# A14

## Cambridge to Huntingdon improvement scheme

TR010018

HE/A14/EX/03 Summary table of responses to s51 advice and s55 checklist

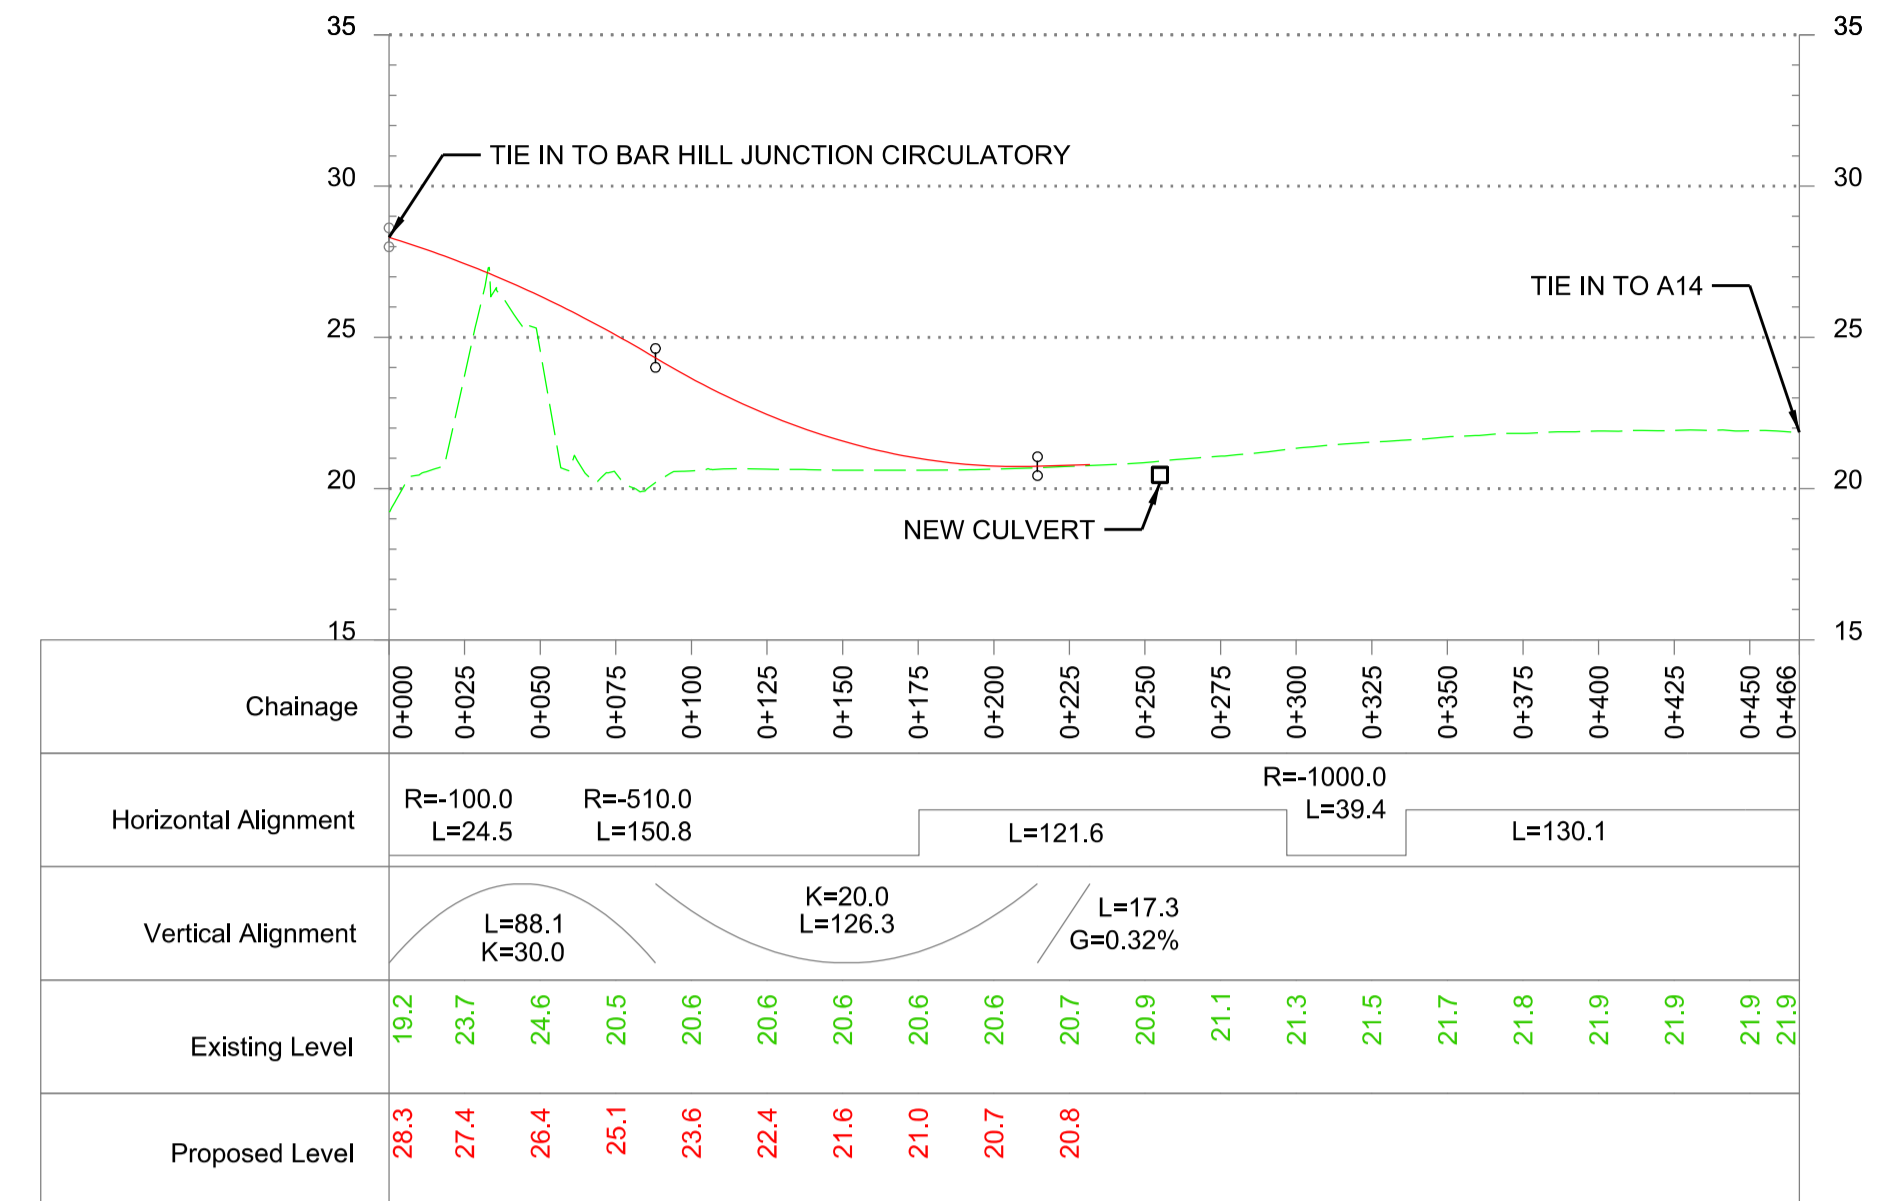
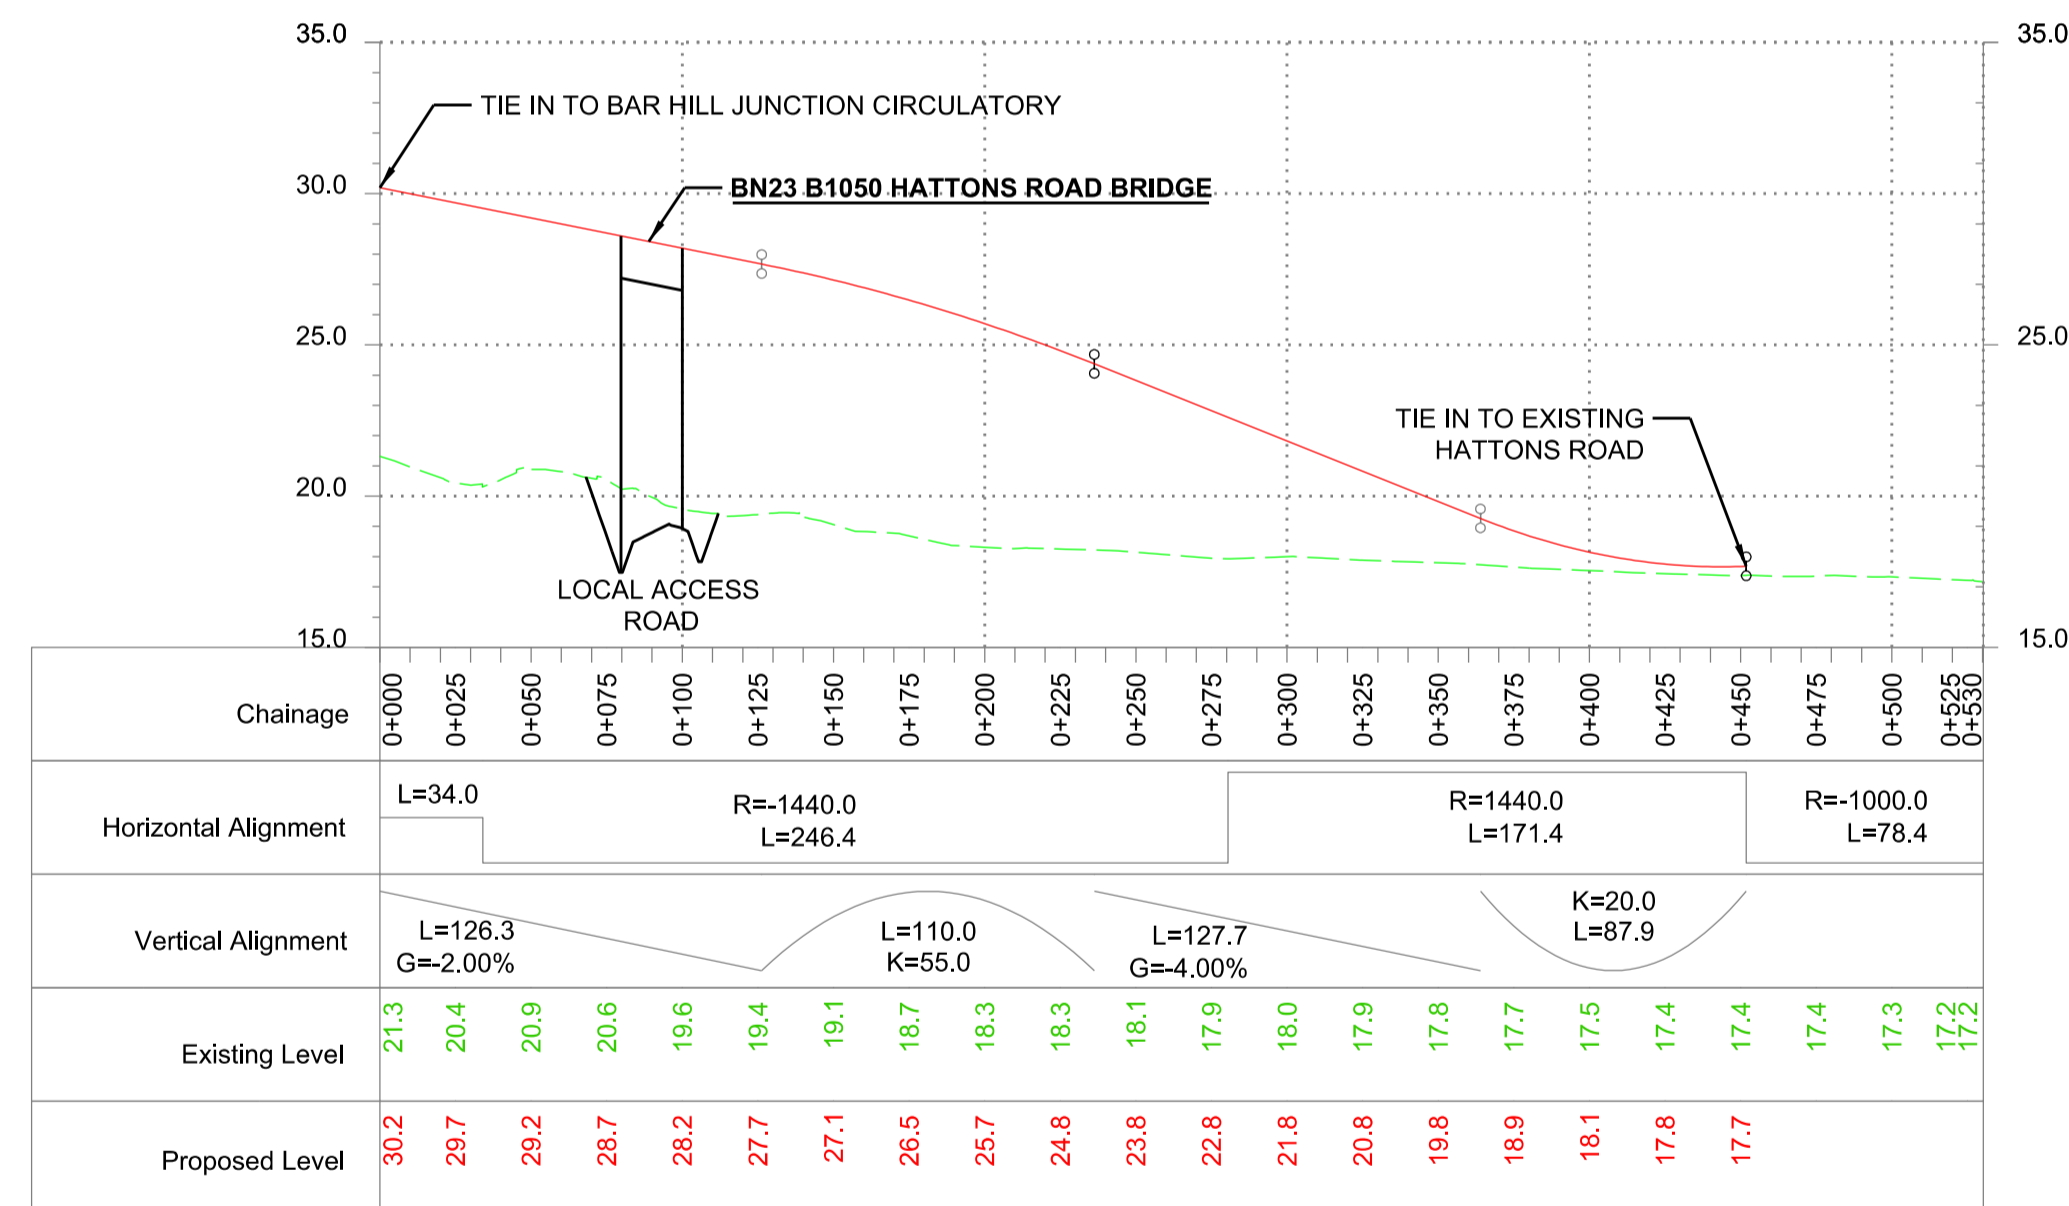
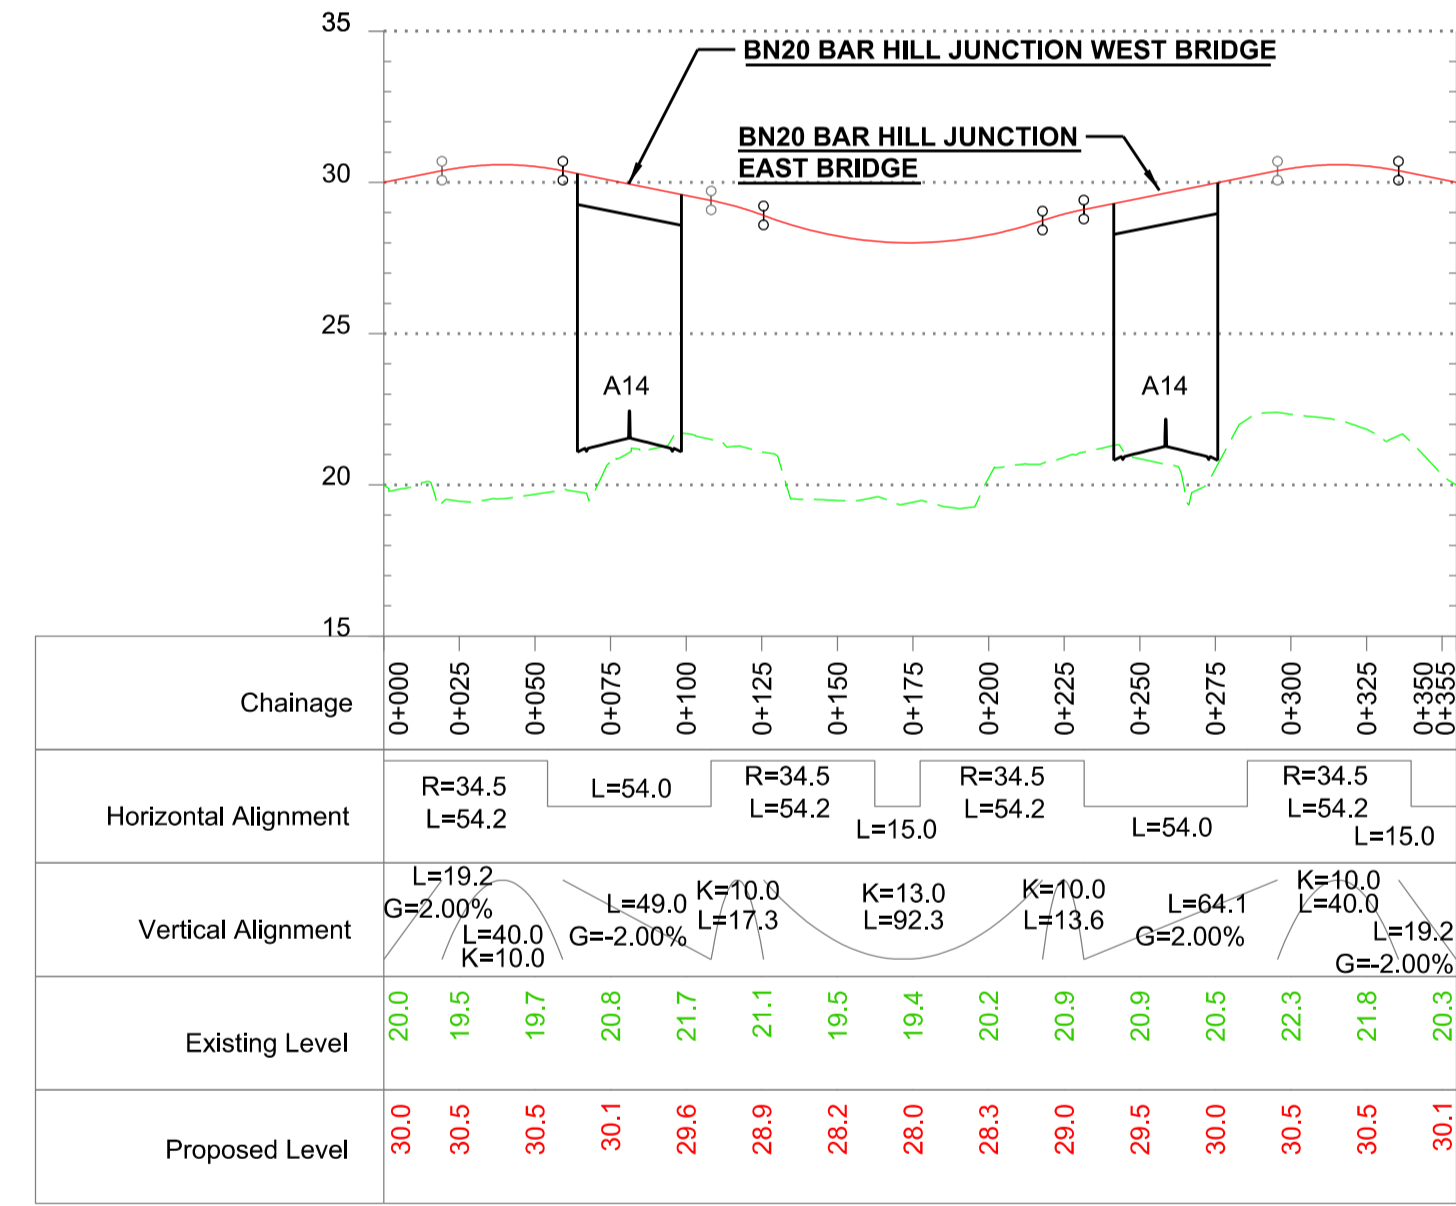
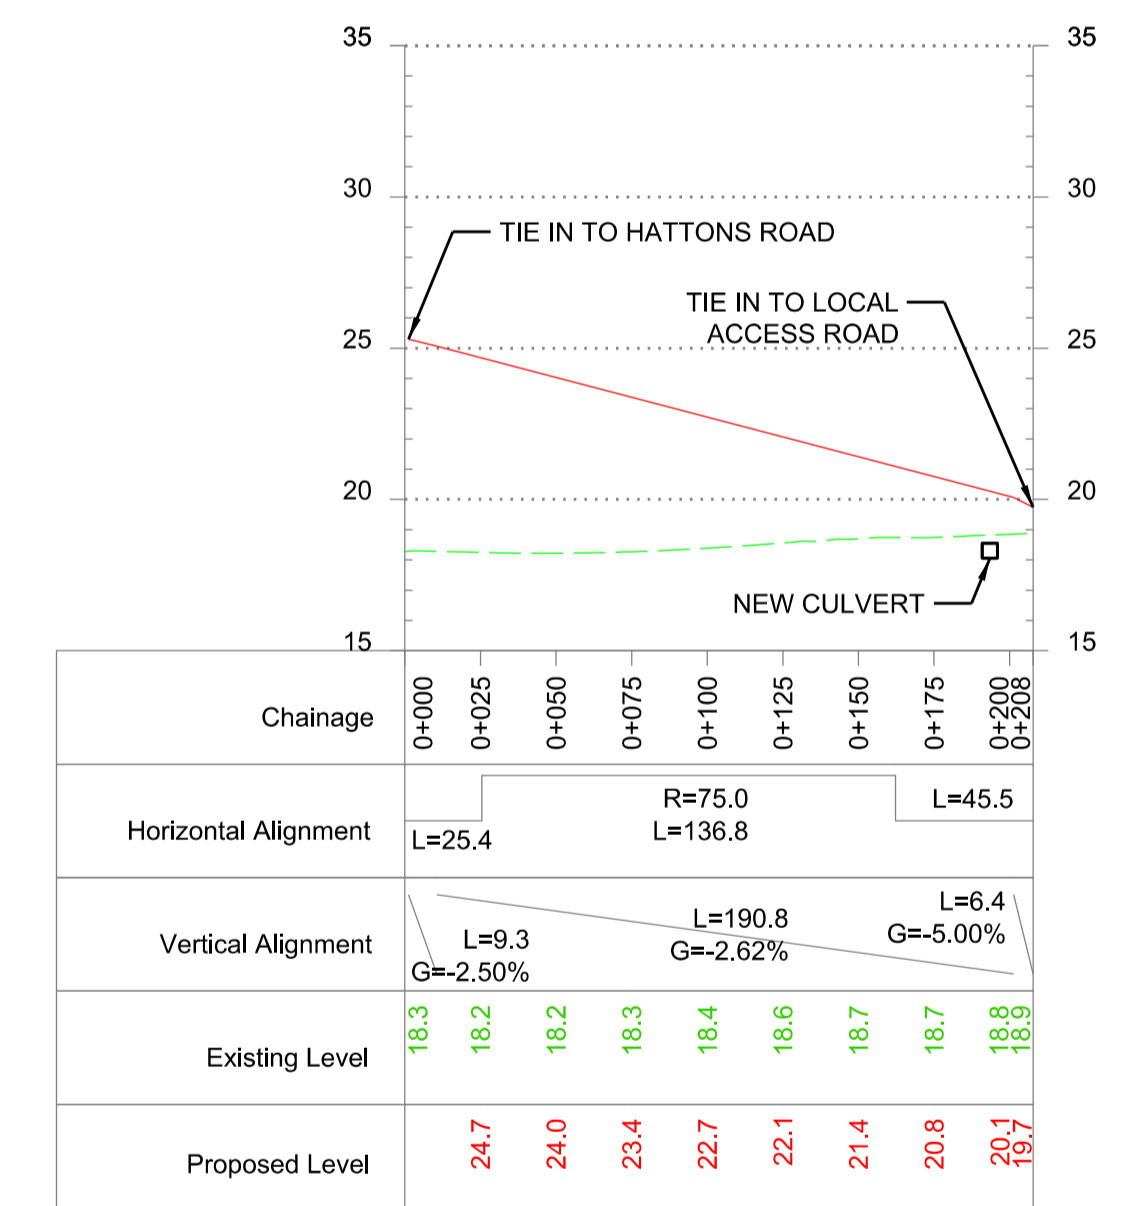
1.10	<p><i>s55 Checklist: Page 25; 3.3 (p)</i></p> <p>There are a number of labelling errors which present a barrier to comprehension:</p> <ul style="list-style-type: none"> <li>• A14 Mainline (sheet 3) – transverse A1 labelled as A14</li> <li>• A1 to A14 Westbound interchange link (sheet 9) – transverse A1 labelled as A14</li> <li>• A14 Eastbound Maintenance Offslip (sheet 14) – onslip labelled as offslip</li> <li>• A1198 Ermine Street North Roundabout Link (sheet 12) – should state that it links north and south roundabouts</li> <li>• Westbound Diverge slip Road (sheet 14) – Emergency maintenance access labelled as diverge slip road</li> <li>• Bar Hill Junction Services Access (sheet 22) – northwestbound merge labelled as northeastbound merge</li> </ul>	<p>The labelling errors identified have been corrected in the updated Sheets, provided in Document Reference HE/A14/EX/07:</p> <ul style="list-style-type: none"> <li>• Sheet 3 is still Sheet 3 in the updated set</li> <li>• Sheet 9 is Sheet 17 in the updated set</li> <li>• Sheet 14 is Sheet 21 in the updated set</li> <li>• Sheet 12 is Sheet 22 in the updated set</li> <li>• Sheet 14 is Sheet 21 in the updated set</li> <li>• Sheet 22 is Sheet 31 in the updated set</li> </ul>	HE/A14/EX/07
